October 27, 2017

**RE: ADU14-003, CAO17-005, SHL17-007-004, Second Review Letter  
Land Use Applications for proposed home, ADU driveway and retaining wall  
construction within a steep slope along the shoreline for the Lady Bug Trust.  
DEV17-009 Impervious Surface Deviation Application has been withdrawn.**

RE: ADU17-003, CAO17-005, SHL17-007, SUB17-004 Second Review Letter  
Land Use Applications for proposed home, ADU, driveway and retaining wall construction within  
a steep slope along the shoreline for the Lady Bug Trust

ENLARGEMENT DETAIL
SCALE: 1" = 10'

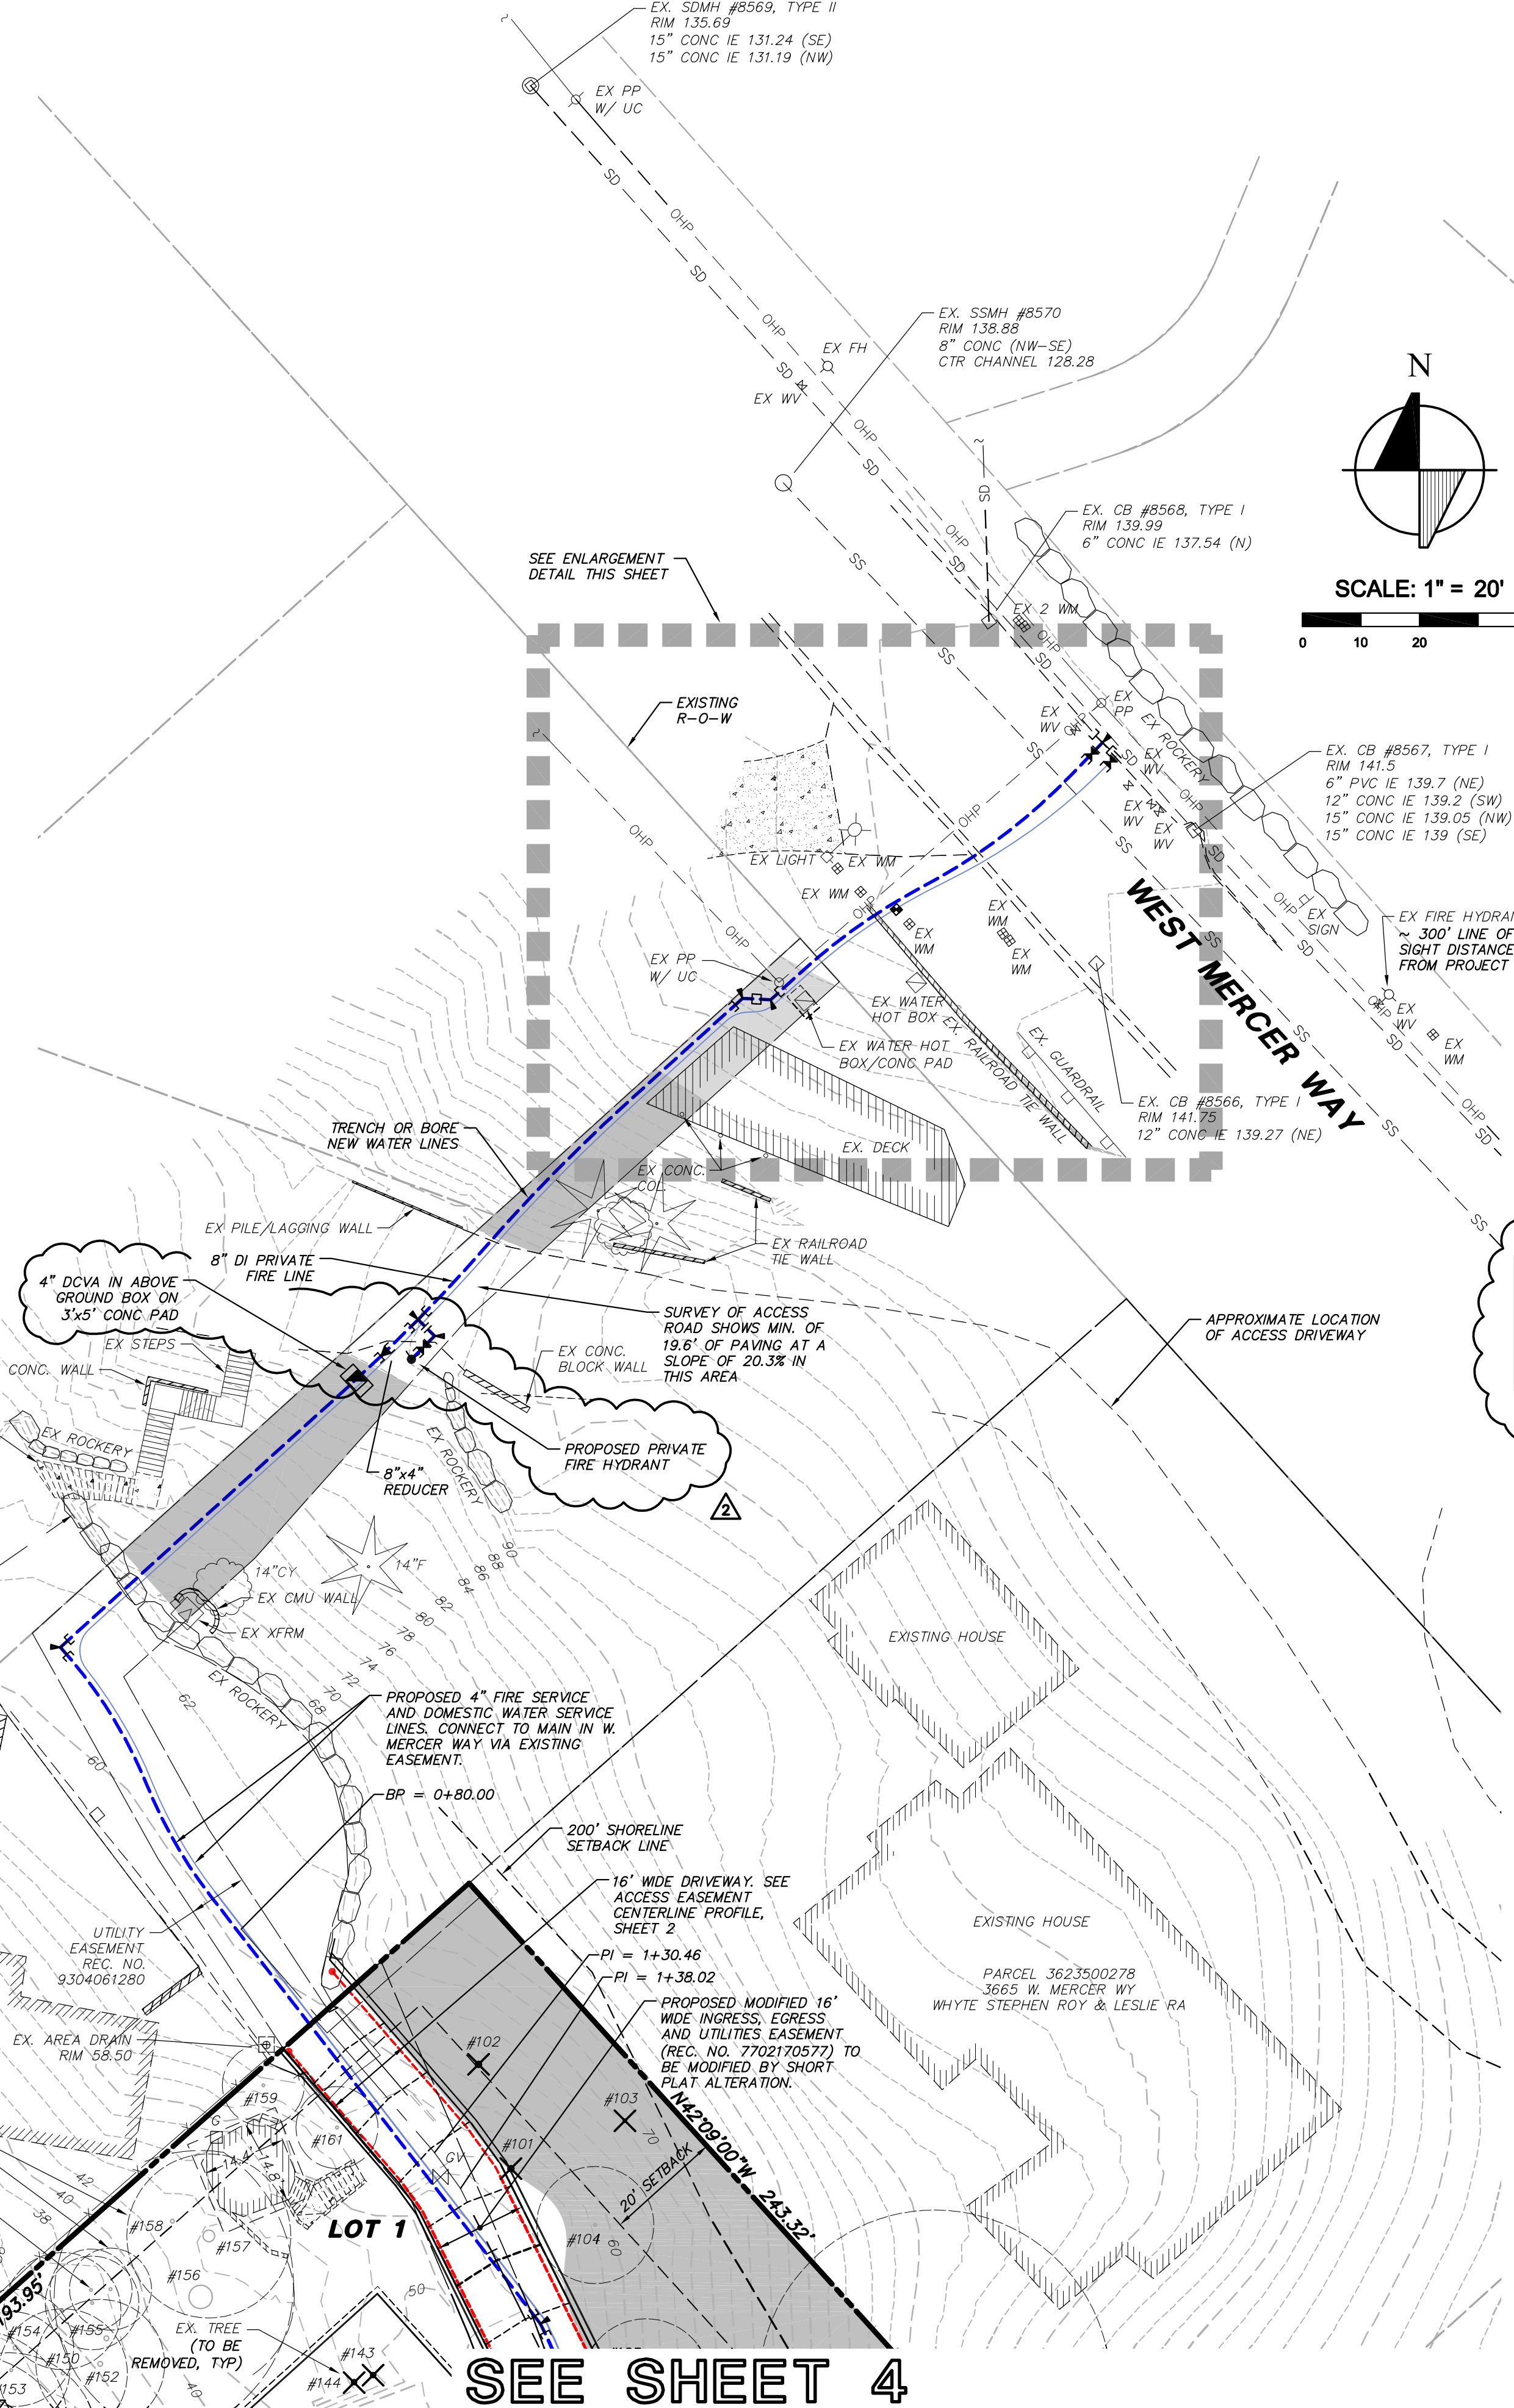
This is not a city water main, it is a private fire line.

Add note: The design of the the this fire line shown on this plan is not reviewed and approved. The design will be reviewed under the building permit.

Please note, if all private water lines must be located in the recorded private utility easement.

**Noted, this line is now referred to as a "Private Fire Line"**

**Noted, language to this effect has been added to the plans.**

**All offsite utility work will occur in the access and utility easement (Rec. No. 9304061280) that benefits the project property. A Box note stating this has been added to the plans.**

CONCEPTUAL GRADING AND UTILITY PLAN
WITH CRITICAL SLOPES

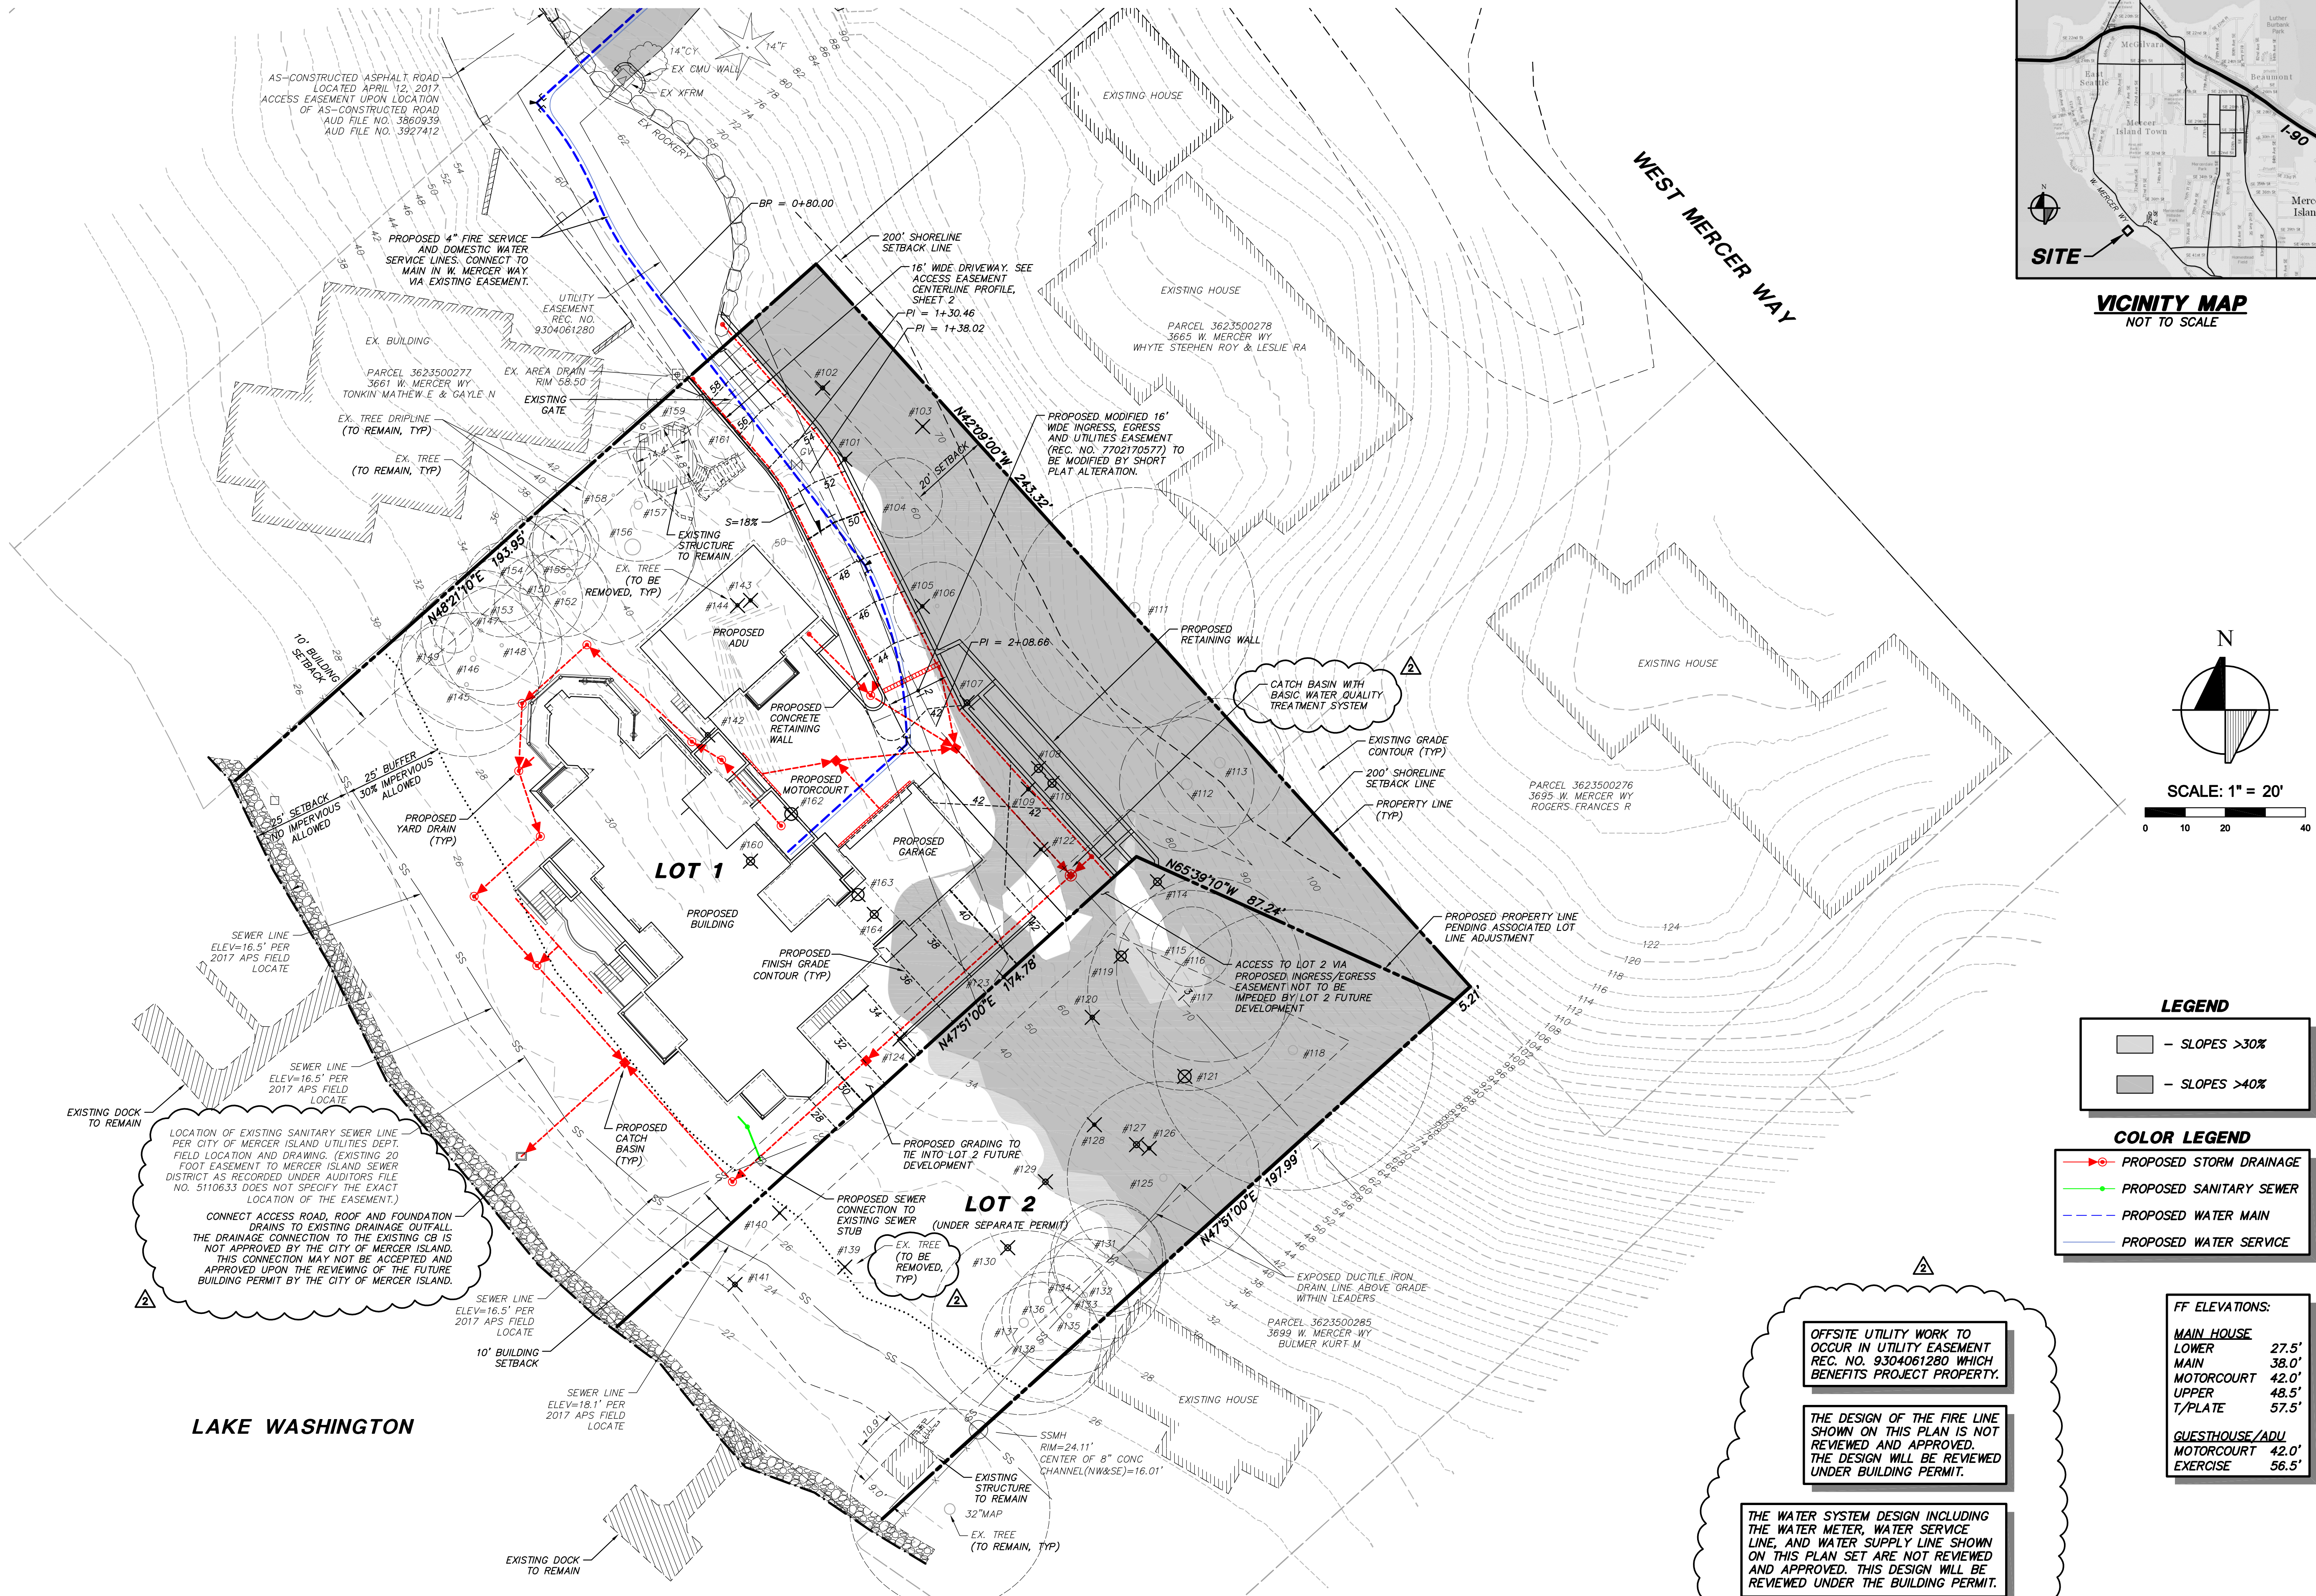
d. Please provide a conceptual grading plan indicating the location of grading and what the proposed grade will be.

**Site grading was shown on the previously submitted Conceptual Grading and Utility Plan sheets (C3 and C4) as well as the driveway centerline profile. These sheets have been updated and are included in this resubmittal.**
